Ribble Valley Borough Council  
Council Offices  
Church Walk,  
Clitheroe  
Lancashire  
BB7 2RA

Phone: 0300 123 6780  
Email: [Kathryn.Walsh@lancashire.gov.uk](mailto:Kathryn.Walsh@lancashire.gov.uk)  
Your ref: 3/2024/0764  
Our ref: 3/2024/0764/HDC/KW  
Date: 26 September 2024

**Location:** Parsonage Farm Church Street Ribchester PR3 3YE  
**Proposal:** Prior approval under Class Q (a) and (b) for the proposed conversion of agricultural barn to one dwelling involving demolition of the attached portal frame building.  
**Grid Ref:** 364308, 435054

Lancashire County Council acting as the Local Highway Authority (LHA) does not consider that the application as submitted fully assesses the highway impact of the proposed development and further information is required as set out in this response.

Proposed Site Plan

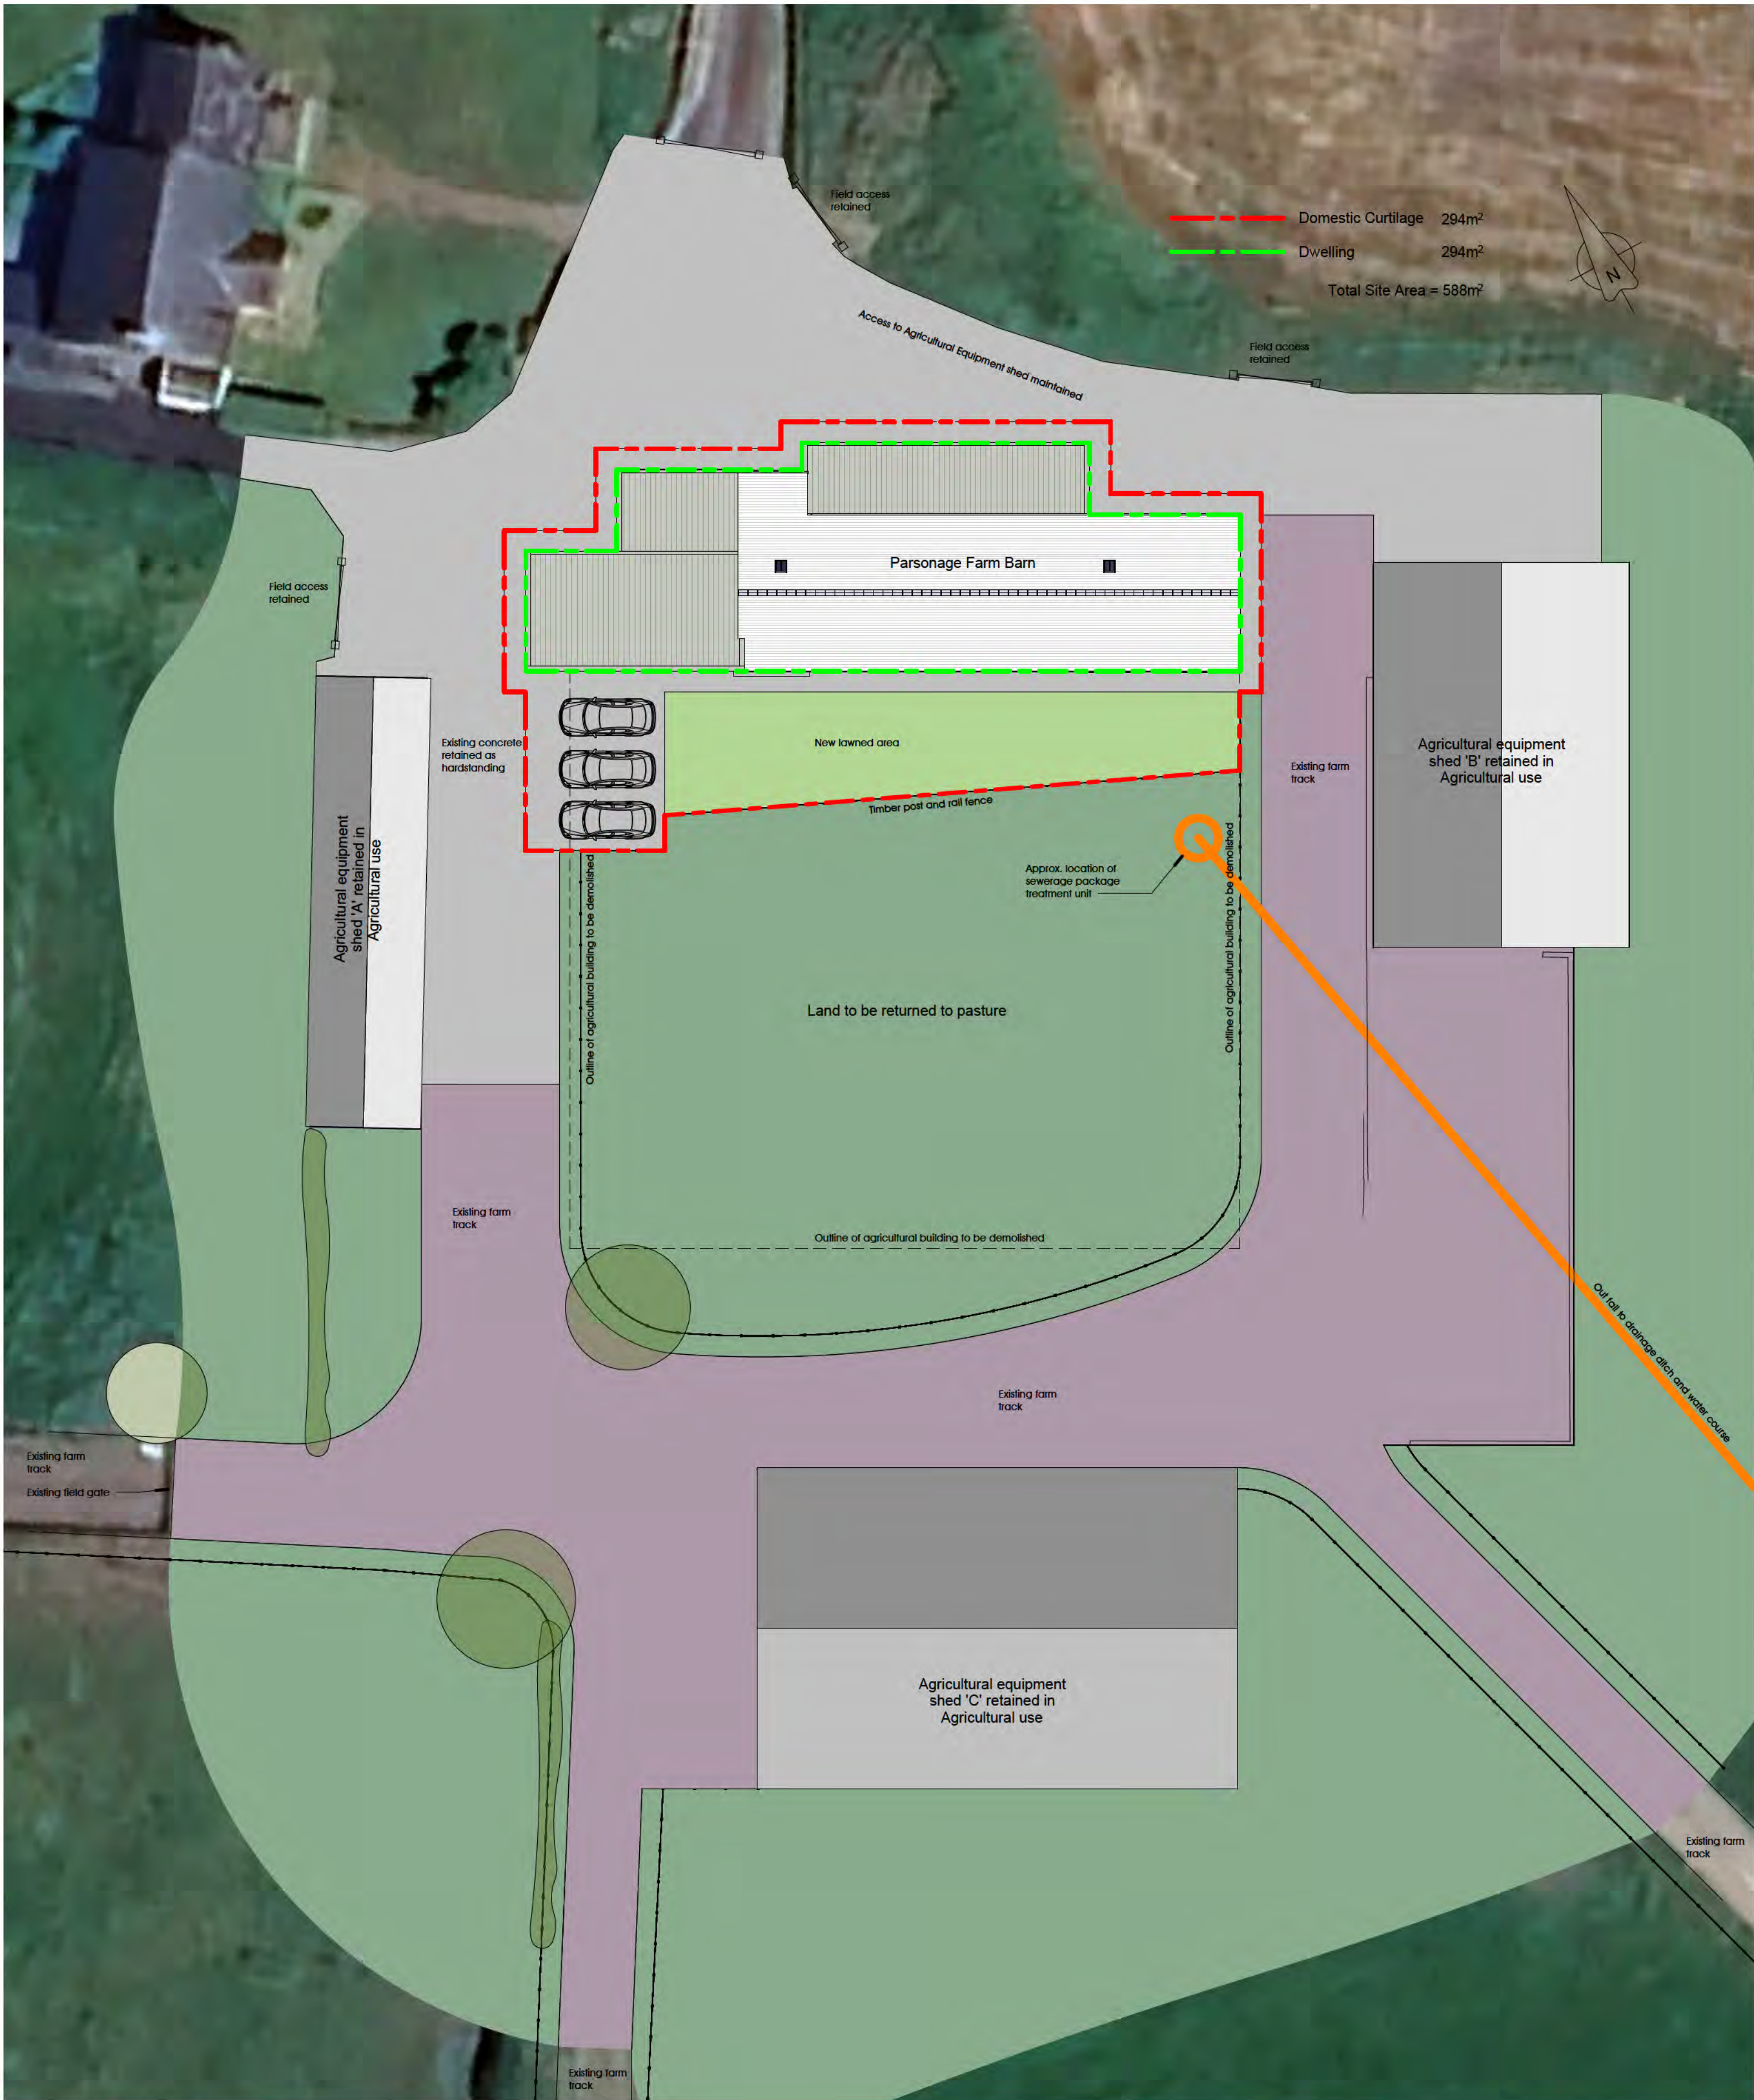
As some agricultural use will remain at the site the LHA requests that passing places be implemented along the unadopted access road, in particular adjacent to the bridge to ensure that two-way movements can occur as well as those which were suggested as part of a previous application, reference 3/2023/0569, at the site.

The LHA requests that passing places be provided and shown within an amended plan, similar to those detailed within a previous application for the site, which will support 2 way movement along the private access road serving the site given the increase in residential use of the site and the retention of some agricultural storage at the site.
